CITY OF ALBUQUERQUE

March 4, 2020

Re: Wecks Restaurant
5115 Central Ave Ne
Traffic Circulation Layout
Engineer's/Architect's Stamp 02-17-20 (k17-d025)

Based upon the information provided in your submittal received 02-19-20, the above referenced plan cannot be approved for Building Permit until the following comments are addressed:

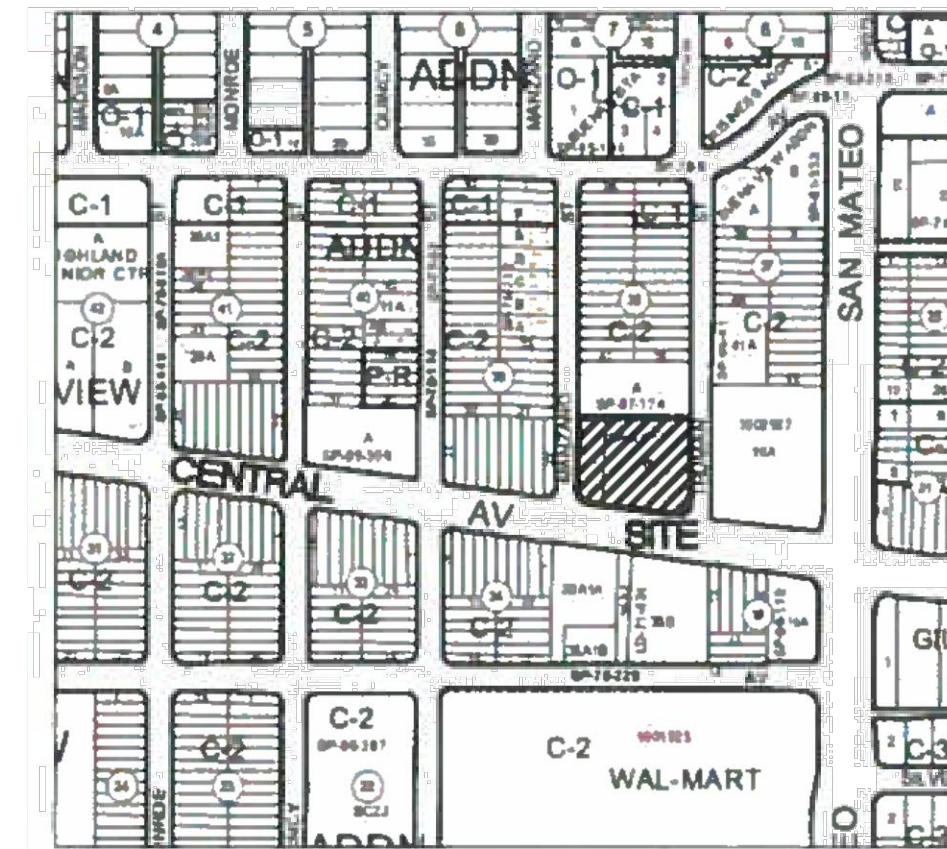
1. Proposed parking calculations need to be coordinated with Zoning.
2. Identify all existing access easements and width dimensions.
3. Please list the length for proposed ADA accessible parking spaces. Some dimensions are not shown.

4. ADA curb ramps must be updated to current COA standards or provide detail.
5. All bicycle racks shall be designed according to the following guidelines:

- a. The rack shall be designed to support the bicycle in an upright position. See the IDO for additional information.
 - b. The rack allows varying bicycle frame sizes and styles to be attached.

- c. The user is not required to lift the bicycle onto the bicycle rack.
 - d. Each bicycle parking space is accessible without moving another bicycle.

6. Bicycle racks shall be sturdy and anchored to a concrete pad.
7. A 1-foot clear zone around the bicycle parking stall shall be provided.
8. Bicycle parking spaces shall be at least 6 feet long and 2 feet wide.

9. Per the IDO, a 6 ft. wide ADA accessible pedestrian pathway is required from the public sidewalk to the building entrances. Please clearly show this pathway and provide details.

10. Per DPM, a 6 ft. wide ADA accessible pedestrian pathway is required from the ADA parking stall access aisles to the building entrances. Please clearly show this pathway and provide details.

11. ADA accessible pedestrian pathway should not be placed behind parking space or adjacent to a vehicular way. Vehicle and pedestrian/wheel chair conflicts should be avoided as much as possible.

12. All proposed sidewalks and ADA accessible pedestrian pathway dimension/widths need to be shown.
13. Truman Street Driveway: provide a detail of median curb and gutter connection onto existing driveway.

14. Please provide a stopping sight distance exhibit instead of clear sight triangle per DPM chapter 23, Section 3.9.5.
15. Show the clear sight line and add the following note to the plan: "Landscaping and signage will not interfere with clear sight line requirements. Therefore, signs, walls, trees, and shrubbery between 3 and 8 feet tall (as measured from the gutter pan) will not be acceptable in the clear sight line.

16. Please specify the City Standard Drawing Number when applicable.
17. Identify any existing access easement and include a copy of your shared access agreement with the adjacent property owner.

18. Add a note stating "All broken or cracked sidewalk and curb & gutter must be replaced with new sidewalk and curb & gutter." A build note must be provided referring to the appropriate City Standard drawings.
